BENHALL & STERNFIELD PARISH COUNCIL
MRS MELANIE THURSTON – CILCA CLERK TO THE PARISH COUNCIL

Planning Inspectorate EN010012

Re: The Sizewell C Project

Benhall & Sternfield Parish request for additional measures to be incorporated into the Sizewell C DCO, to mitigate against the currently poor design of the Two Village Bypass (TVB) and the effect that it will have on the dwellings near the A12 and those in the Farnham Hall area.

DRAWING TITLE:
 TWO VILLAGE BYPASS
 PROPOSED LANDSCAPE MASTERPLAN
 AND FINISHED LEVELS
 SHEET 2 OF 2

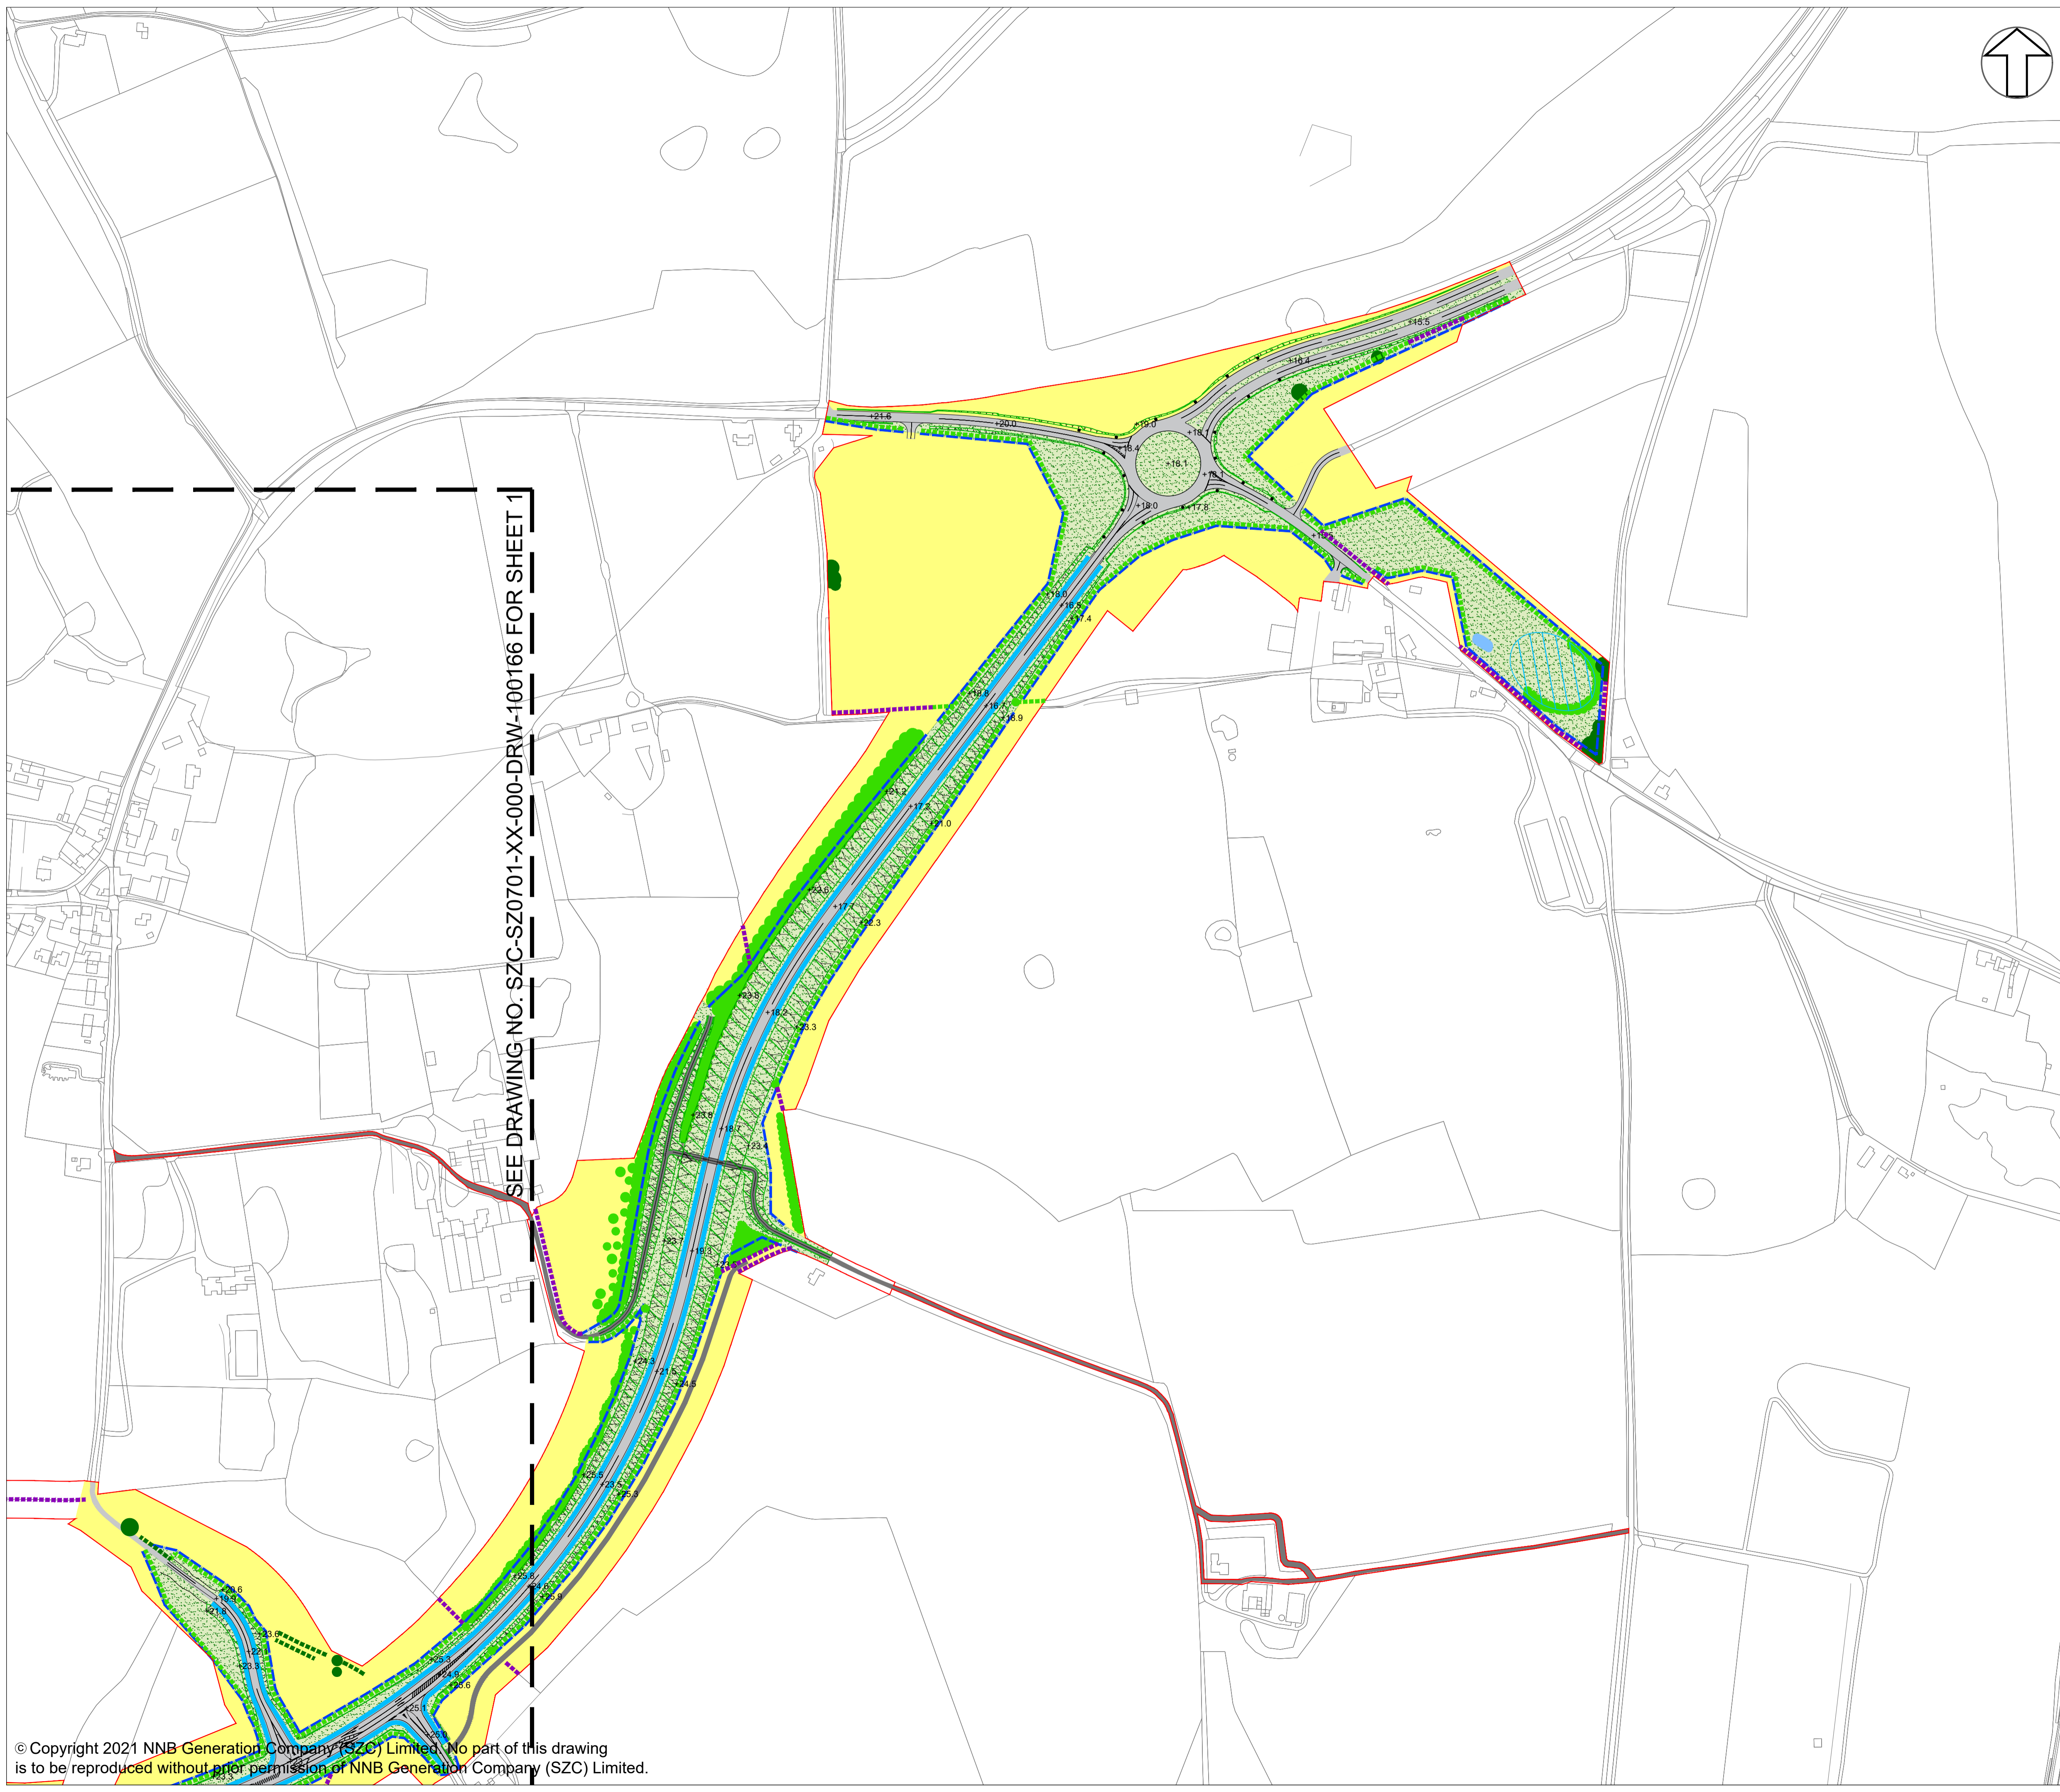
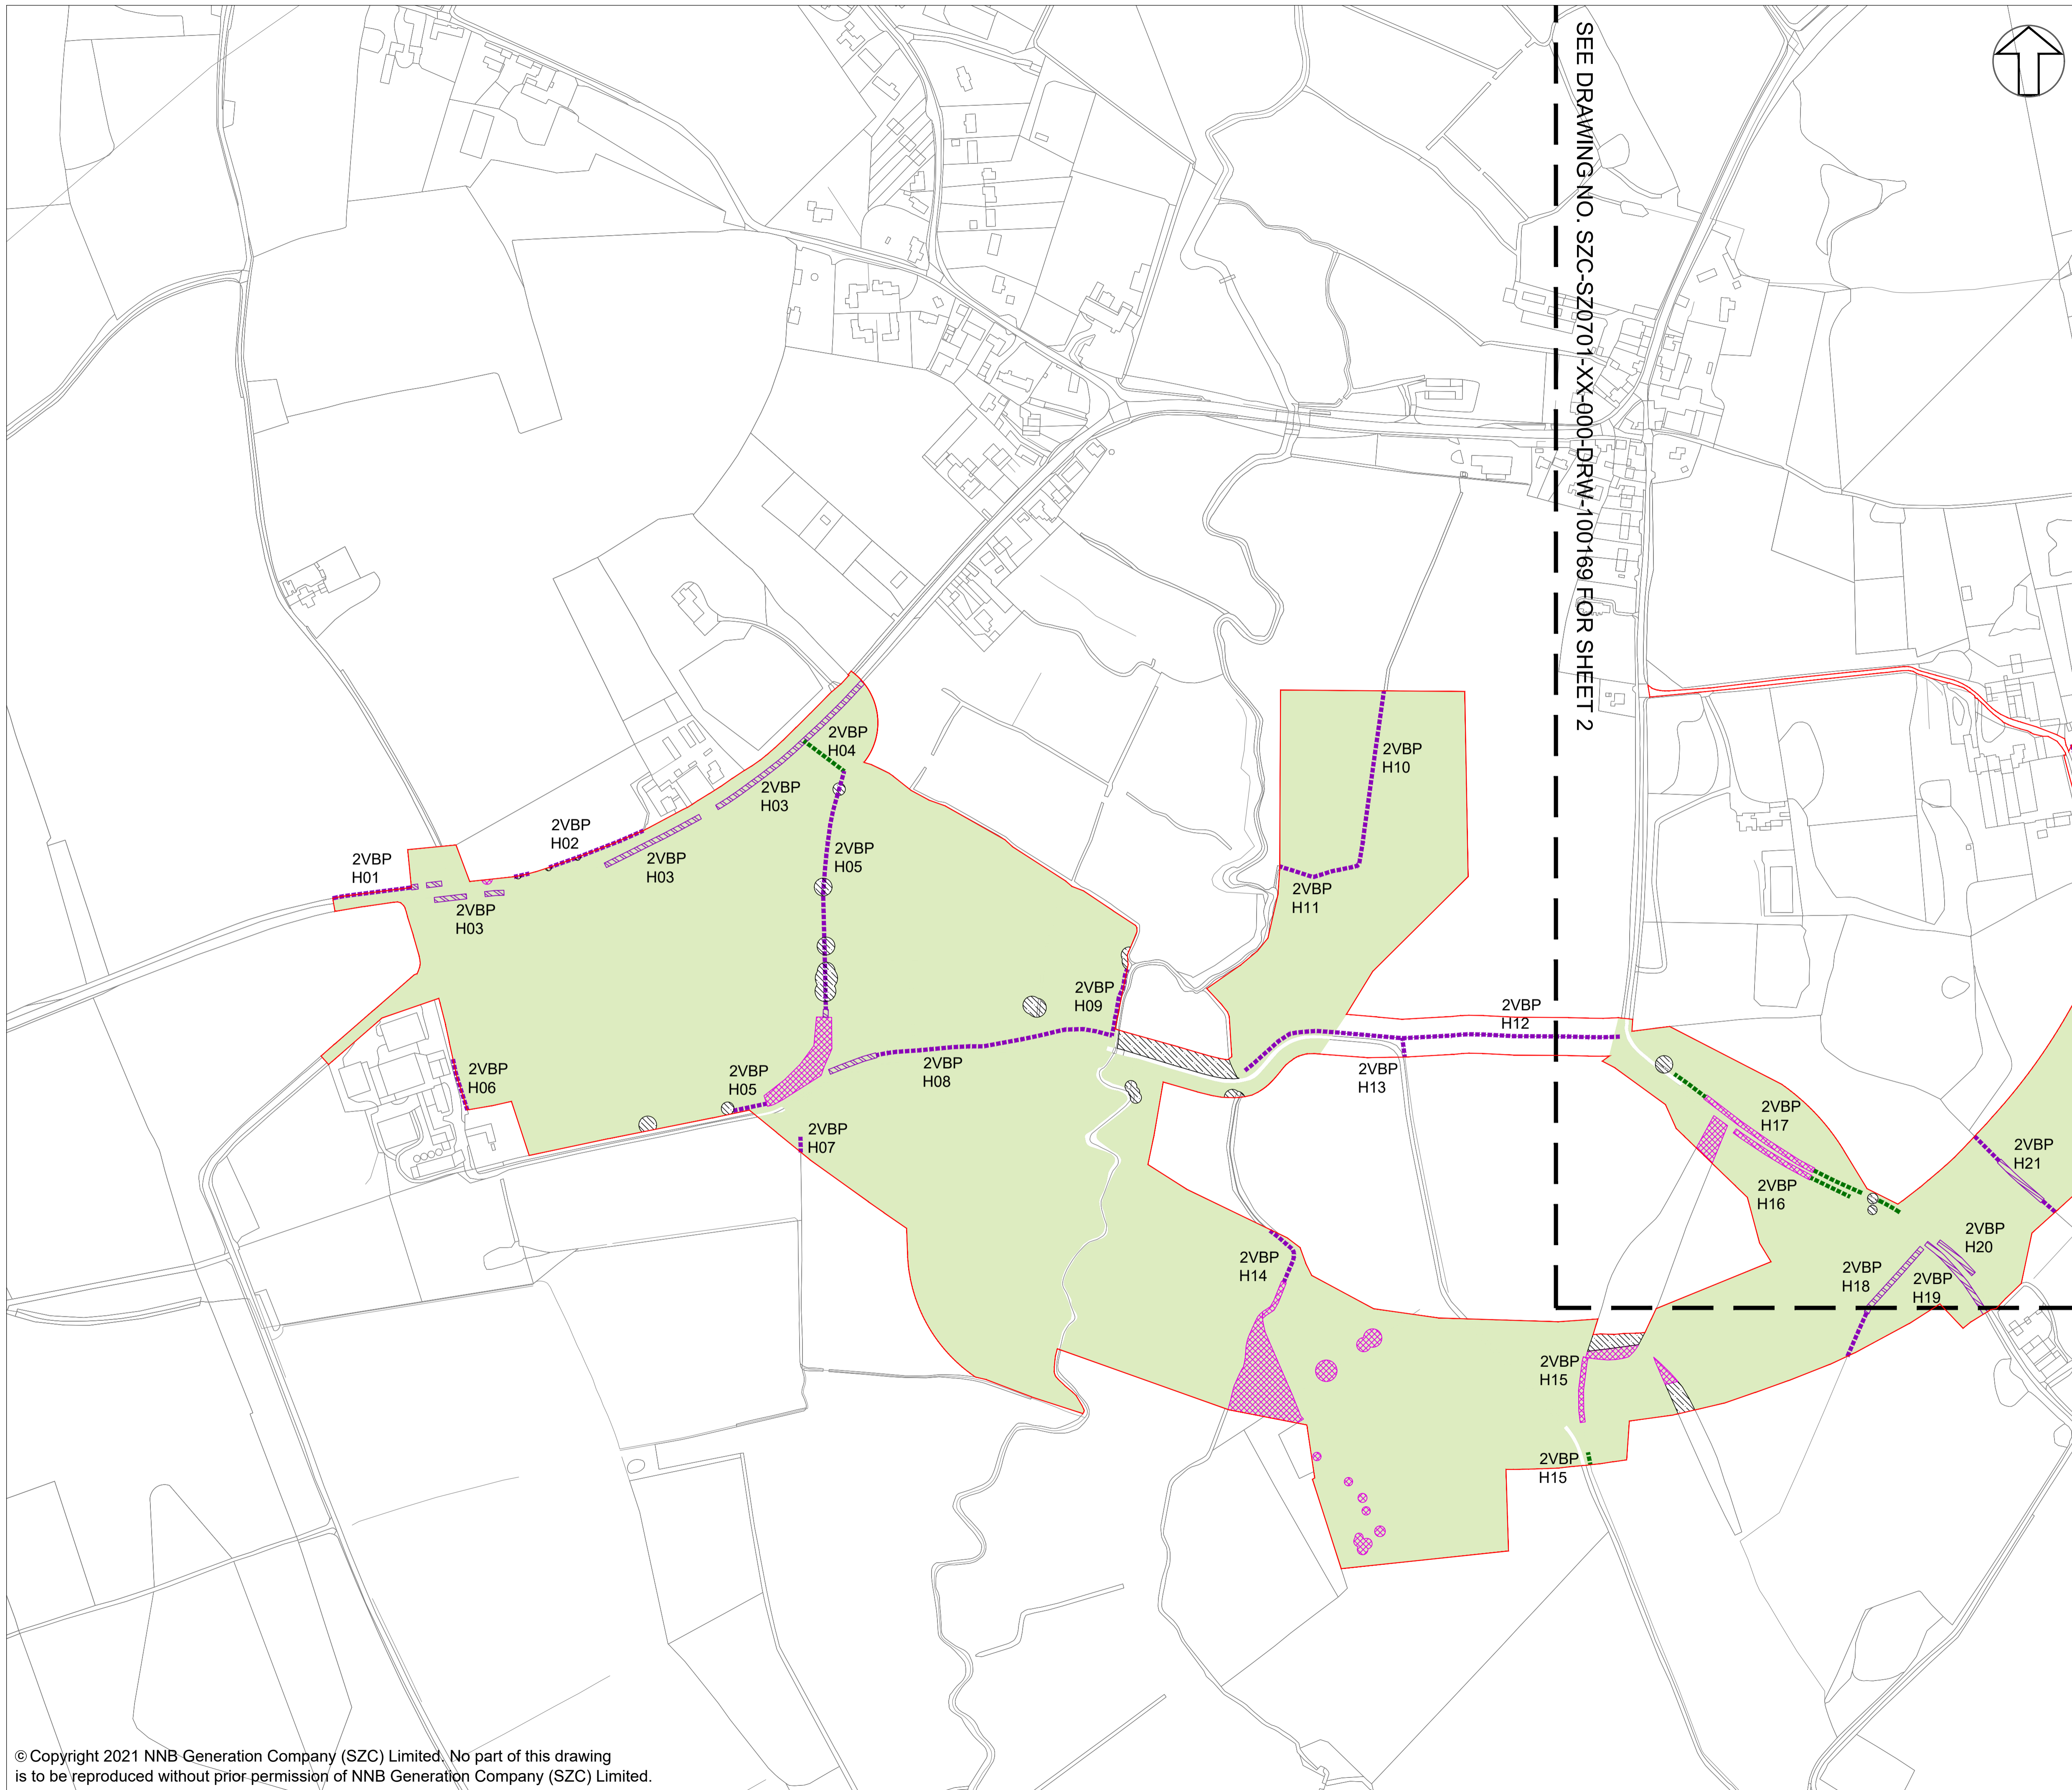
- A bund parallel to the route of the proposed Two Village Bypass to screen business' and parts of property.
- Visual and screening noise attenuation fencing around the eastern construction compound.
- Additional soft and hard landscaping to absorb the bypass into its setting.

We therefore ask for a better TVB design that includes noise-mitigating bunding along the western edge of the northern section (between Friday Street and the Farnham Hall area), low-noise road surfacing in the same zone and safe pedestrian crossings for all four arms of the Friday Street roundabout. We believe that, taken together, these measures will be of significant benefit to all those concerned – which amounts to 17 residential dwellings, Molletts Farm - tourism-led business (which hosts over 1,000 guests a year and contributes to the local economy) and those that live and enjoy walking around the local area.
